From: Sue Howell
Sent: 28 May 2019 15:01
To: Planning.Responses
Cc: Anita Gardner
Subject: RE: Planning Consultation on: FG/29/19/PL

Town & Country Planning Act 1990 (as amended)
Town and Country Planning (Development Management Procedure)
(England) Order 2015
Planning Permission
APPLICATION **FG/29/19/PL**
NO:

Site Address: South Point 1 Beehive Lane Ferring BN12 5NL

Description of Erection of 1 No. 2 bed dwelling
Works:

Scale: 1:100@A1	Drawn: AR	Date: 13-07-15
Drawing Number: RCo 155 / 02	Revision: 04

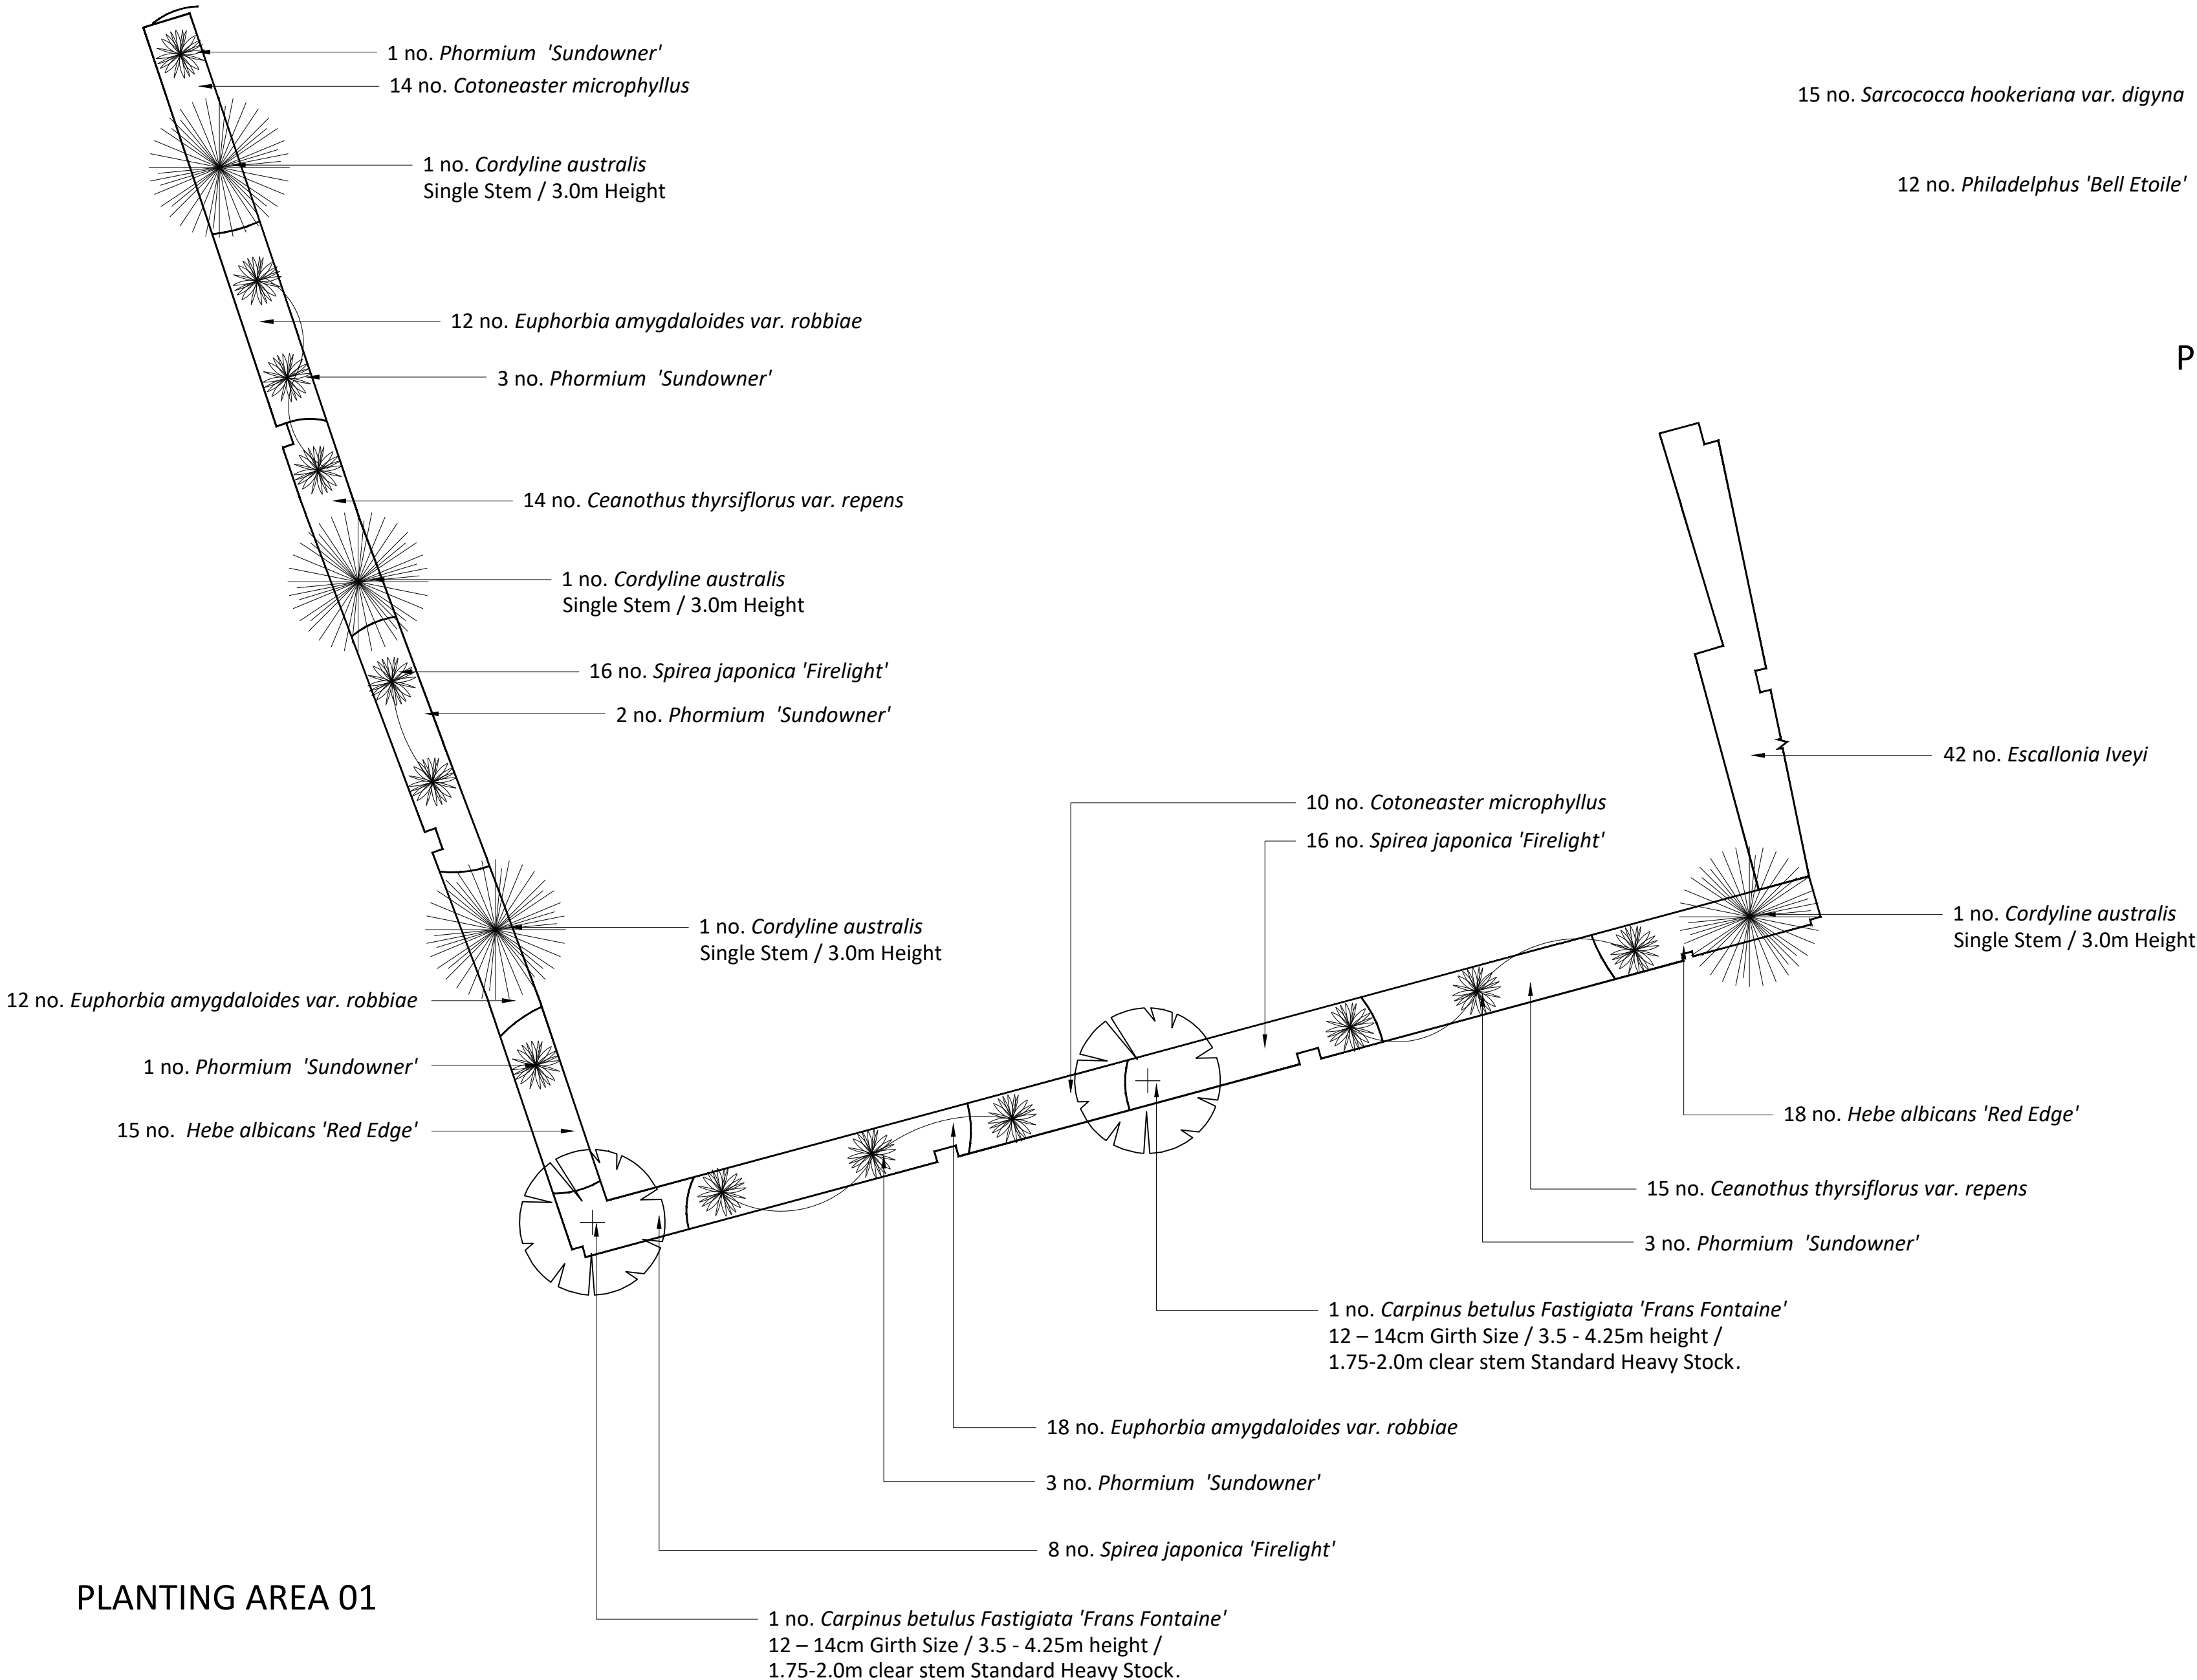
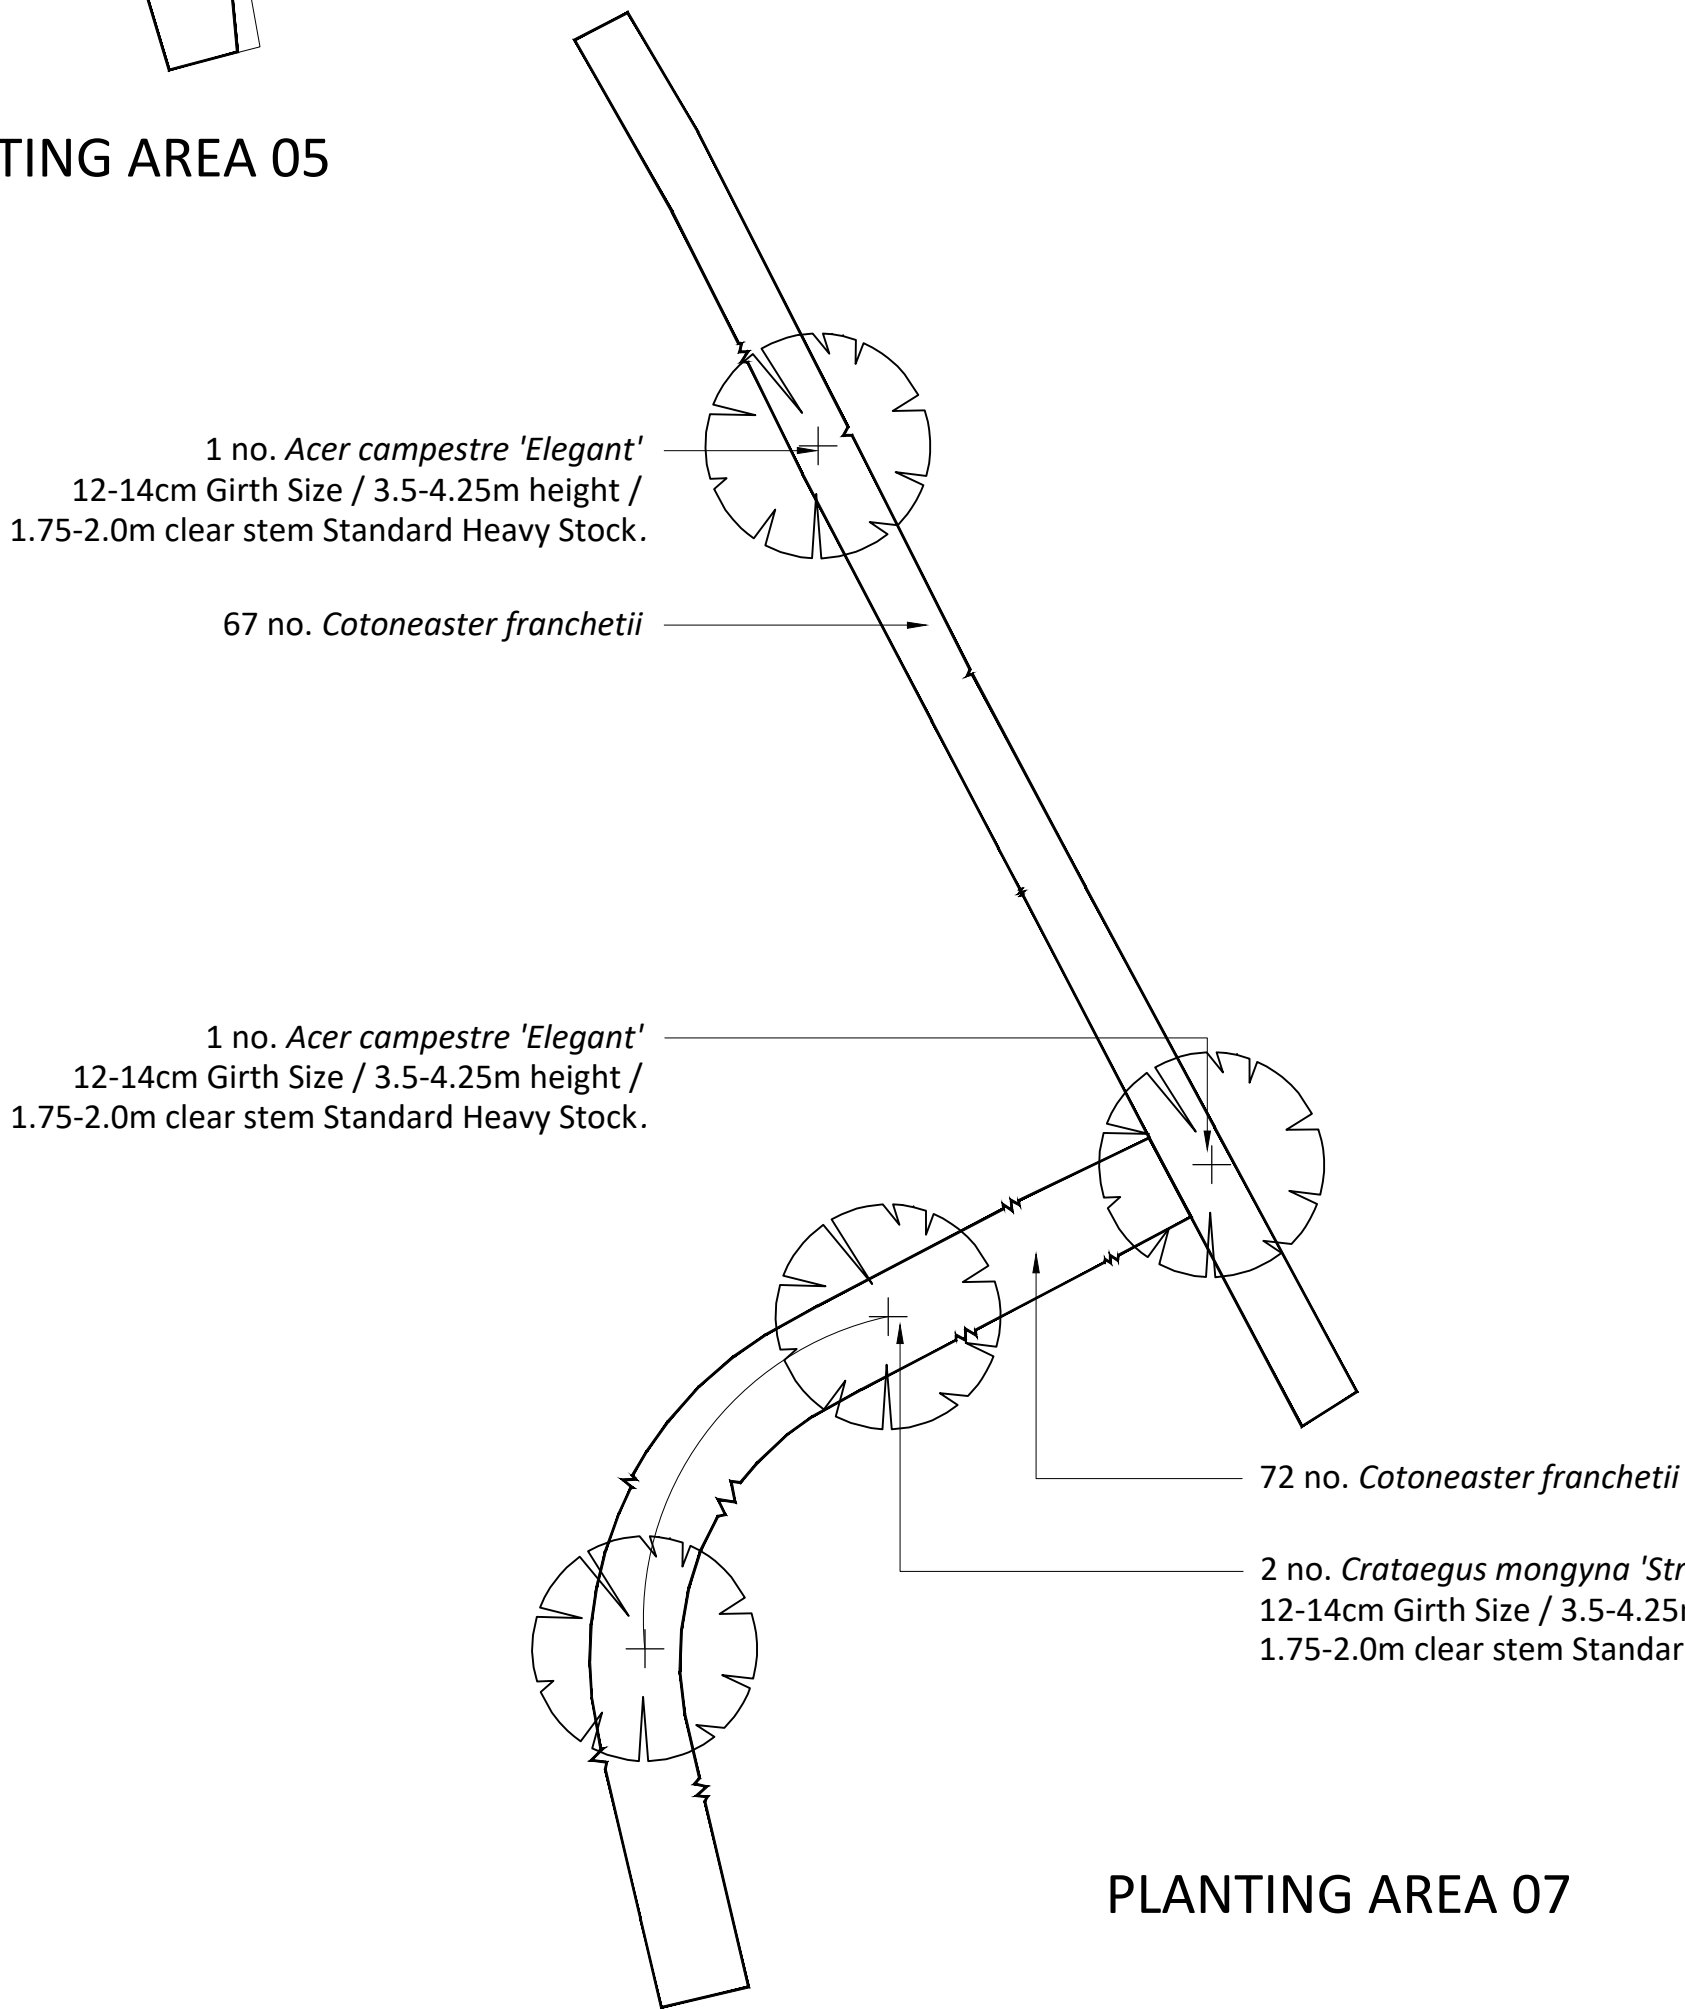
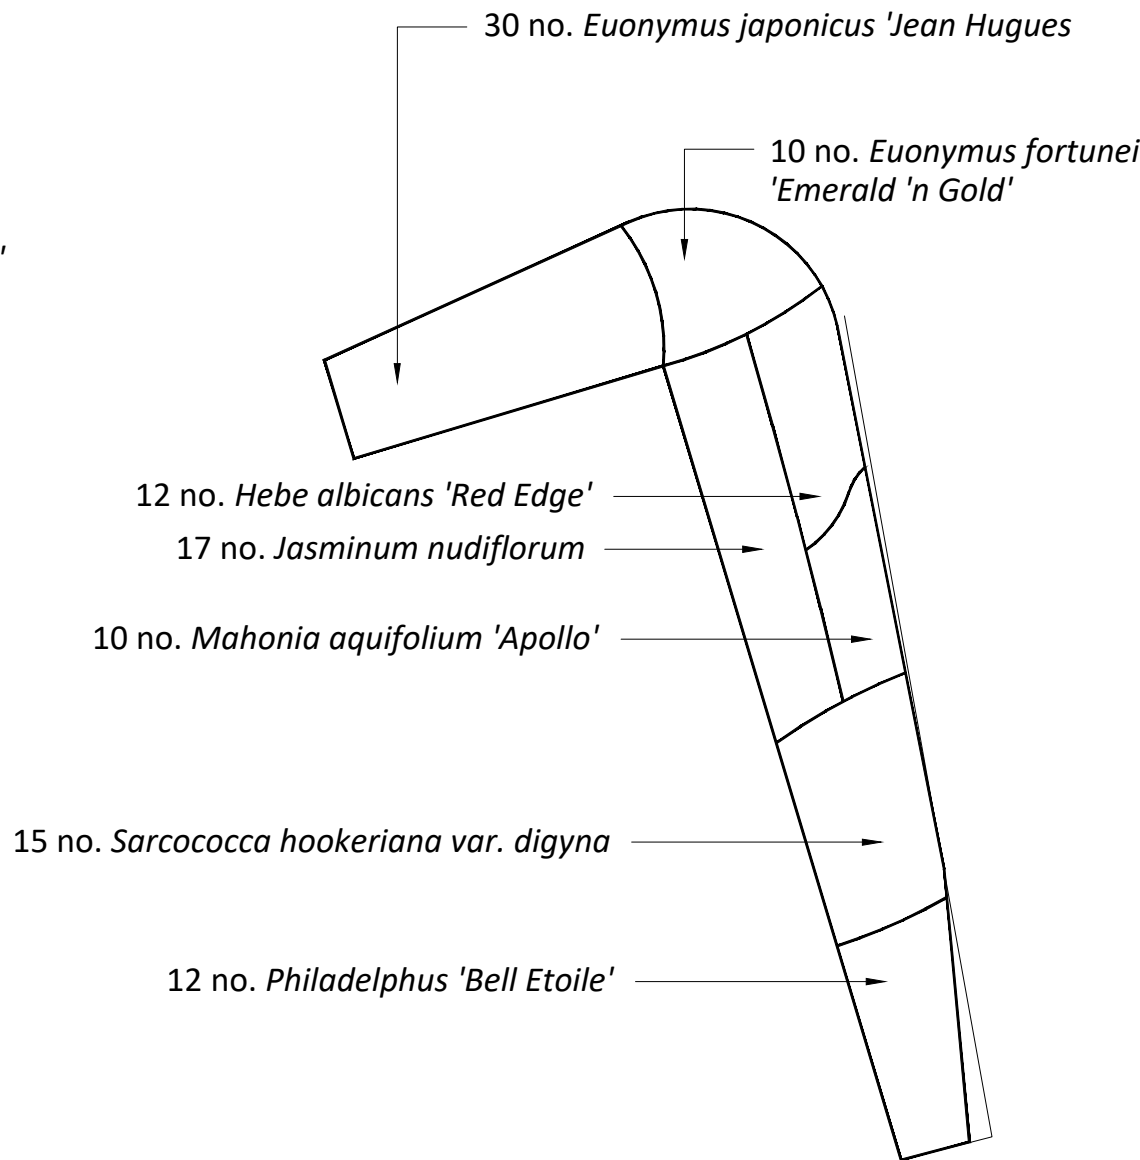
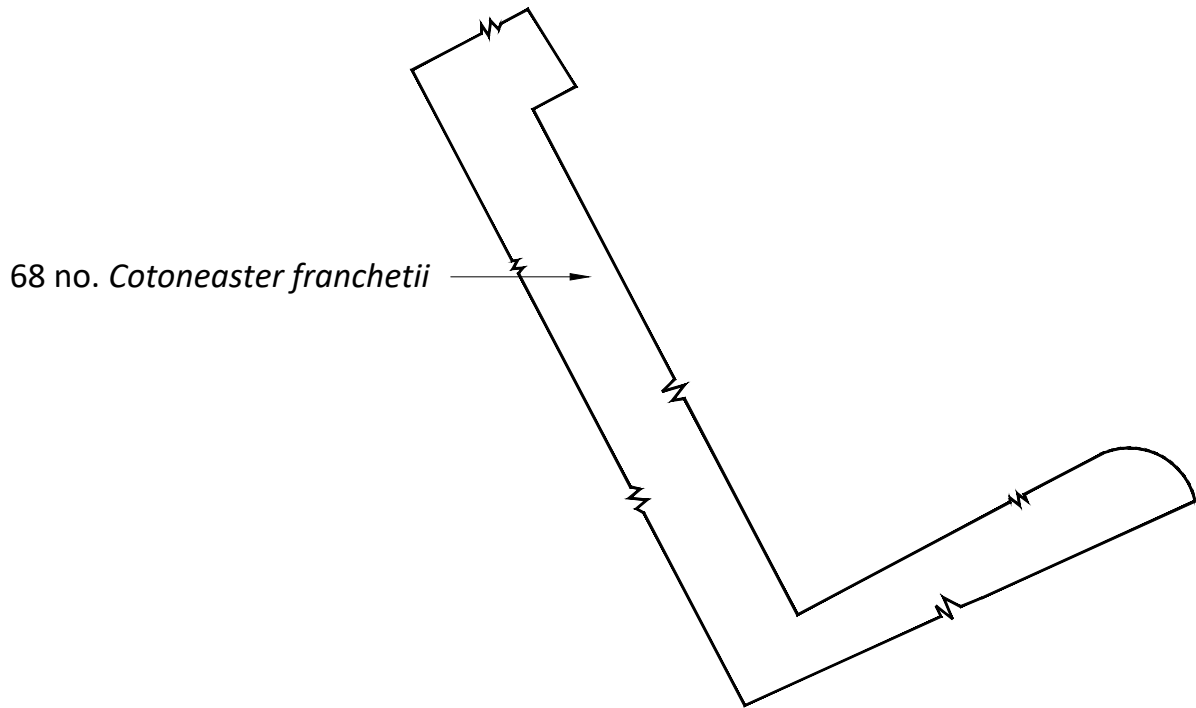
The landscape Detailed Planting Plan RCo 155/02 Rev 04 has provided a scheme which is varied, detailed and proposes a scheme which is appropriate for location. The detail shown has incorporated blocks of planting, specimen plants and trees. The inclusion of specimen shrubs and trees will give a certain degree of instant screening which will assist in blending the proposals into its surrounding, offering some screening and increasing the biodiversity of the site.

The plans have detailed a scheme showing plant species, planting densities and size at time of planting.

My recommendation is that the detail provided is appropriate for location and in sufficient detail. I would recommend no landscape objection, subject to the landscaping being implemented ideally before occupation and no later than the first planting season post completion.
